From: Amanda Scholes on behalf of Planning.Responses
Sent: 12 March 2018 09:29
To: Planning Scanning
Subject: FW: 12 Raleigh Road

Proposed Garage and Utility room. 12 Raleigh Road, Bognor Regis, West Sussex.
Proposed Ground Floor and Roof Plan. Drawing Number = 10 Scale 1:100 @ A3

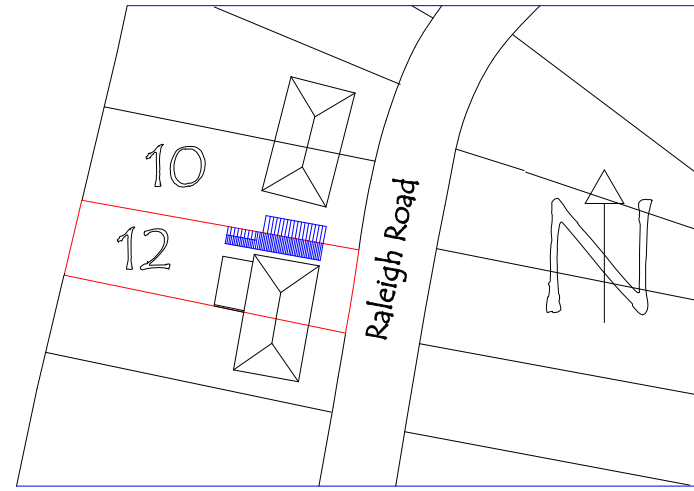
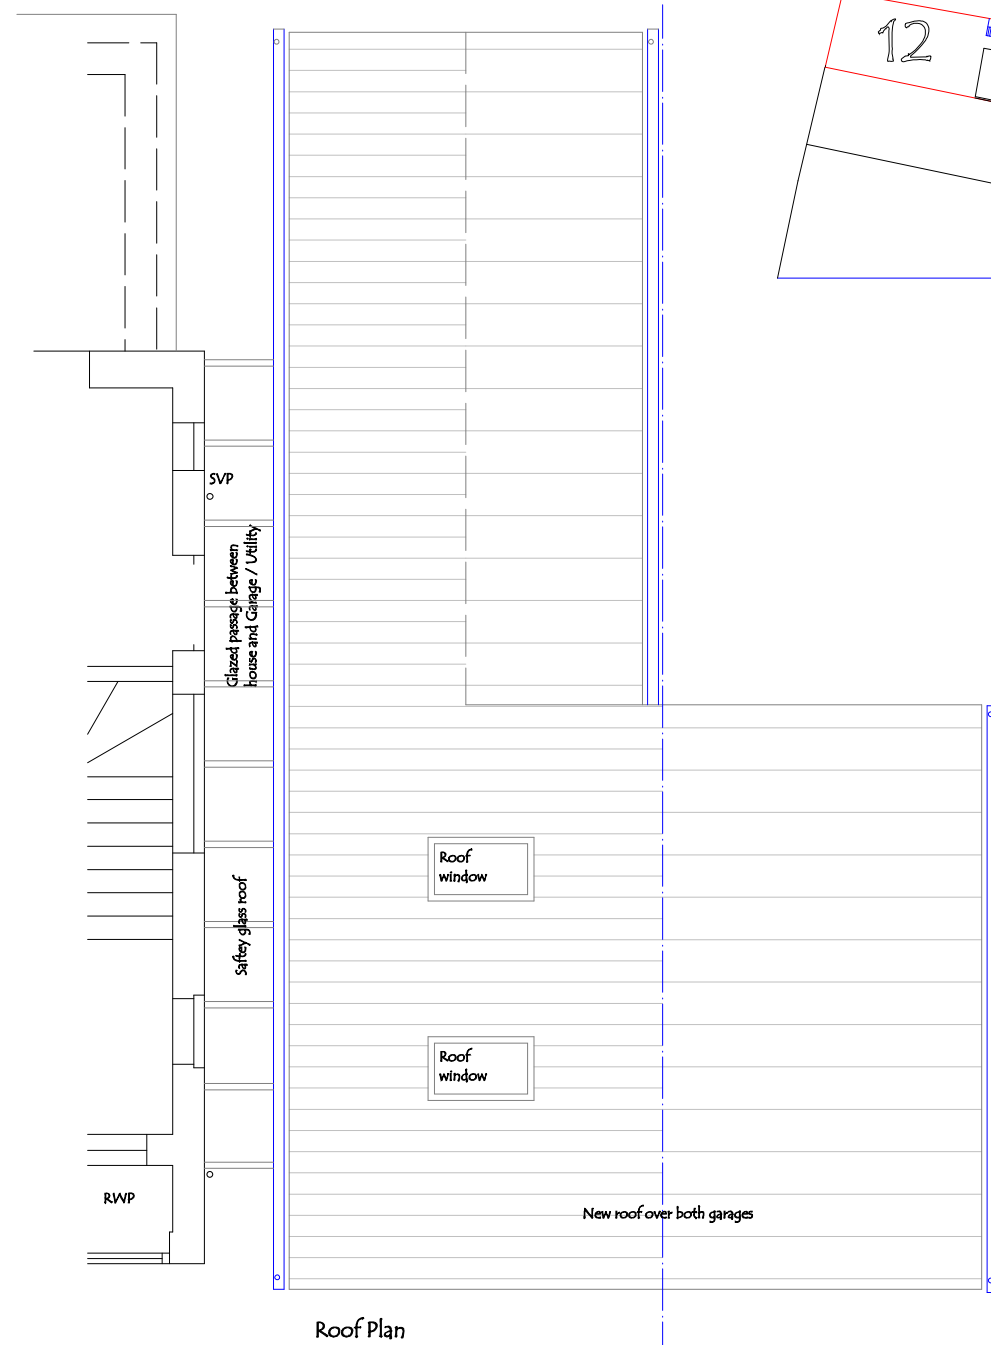
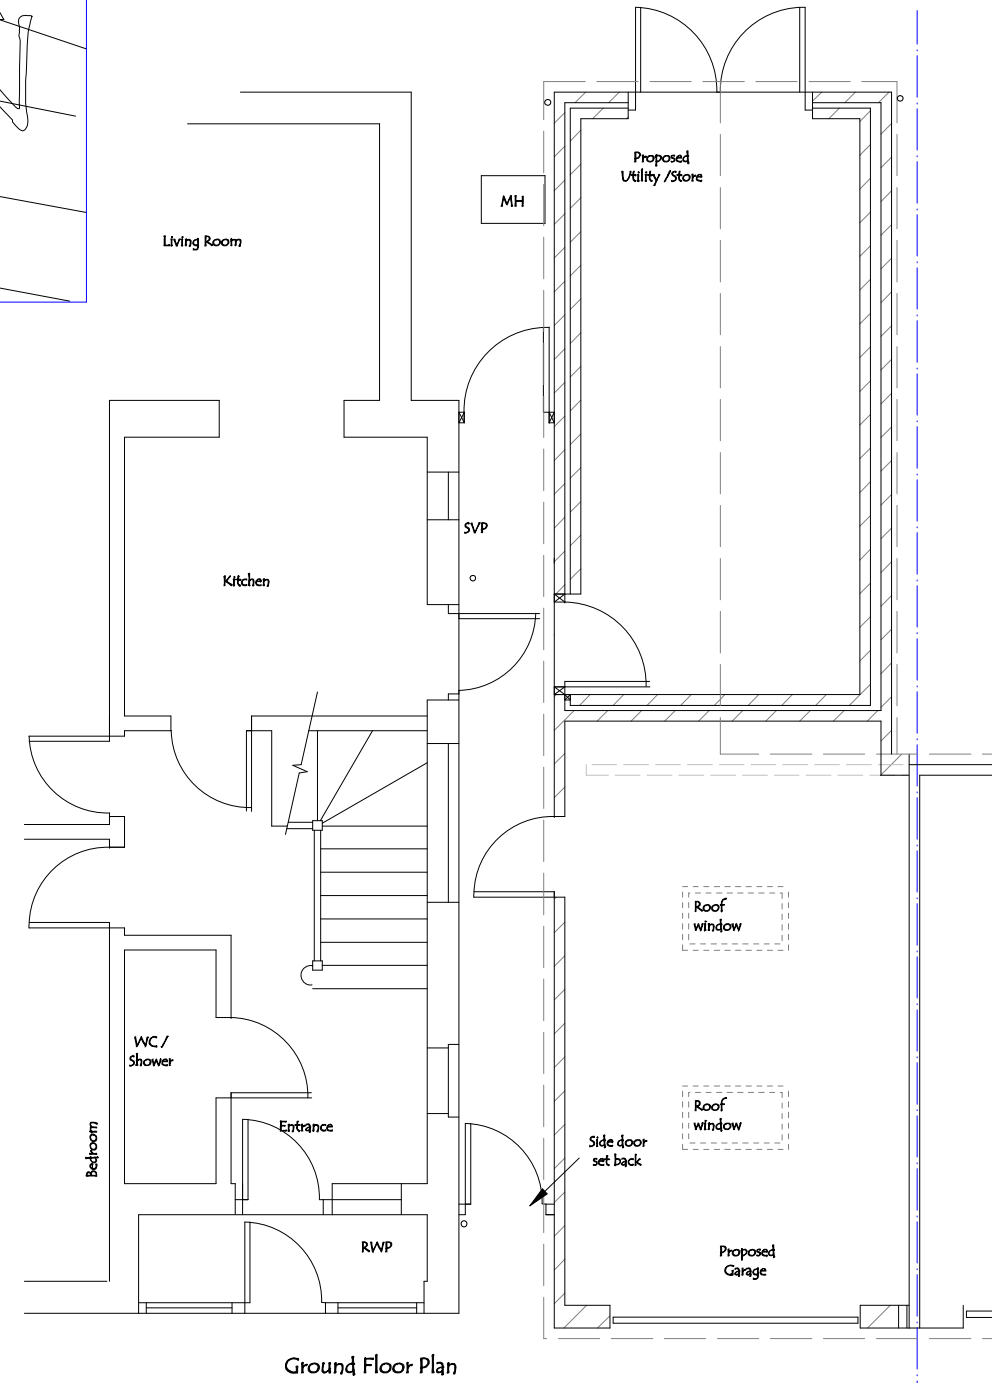
1. The plans are amended to remove the proposed roof on the neighbouring property No.10 and make a separate application for No.10 or leave No.10 out of consideration.

2. The application form changed to reflect 10 and 12 including the description . In addition the red line would need to change on location plan to include No.10. Also certificate B would be required if the application is in your name and notice served on the owner of No.10, as mentioned these forms can be obtained on the planning portal. We would need to agree an extension of time for the application to allow a revised application to be re advertised.

That was my assumption and can see the point. However, I believe the application form, description and site plan will need to change as the current application only has No.12 as the site and it will need to be No. 12 and 10. Also my understanding that if you submit the application you will need to serve notice on the occupiers of No.10 and sign certificate B. Forms are on the planning portal which you used to submit the application.

Proposed Garage and Utility room. 12 Raleigh Road, Bognor Regis, West Sussex
Proposed Elevations. Drawing Number = 11 Scale 1:100 @ A4

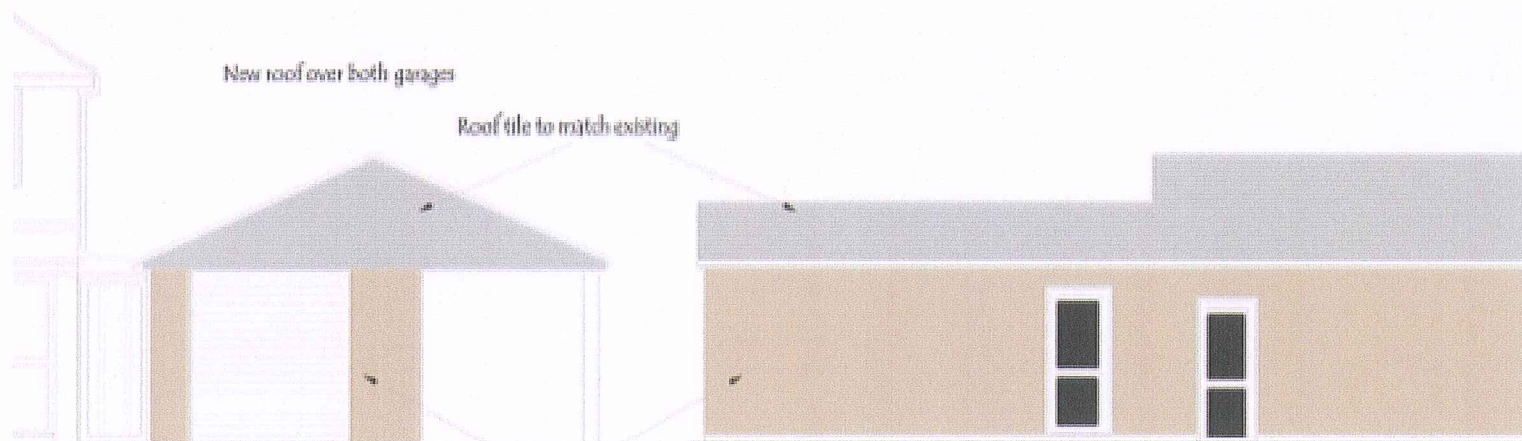
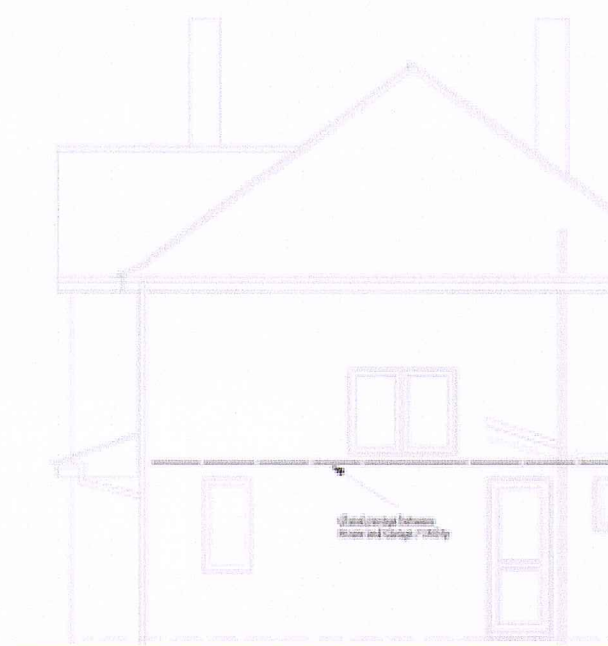
Apologies for delay in coming back as I mentioned I was on leave last week. In this time the team manager has confirmed my opinion and the application would need to be changed

Can you confirm if the new roof over the garage at No.10 is part of the current application.

The roof at no. 10 is currently flat.

We are proposing a pitched roof across both properties in the application to enhance the appearance of both properties.
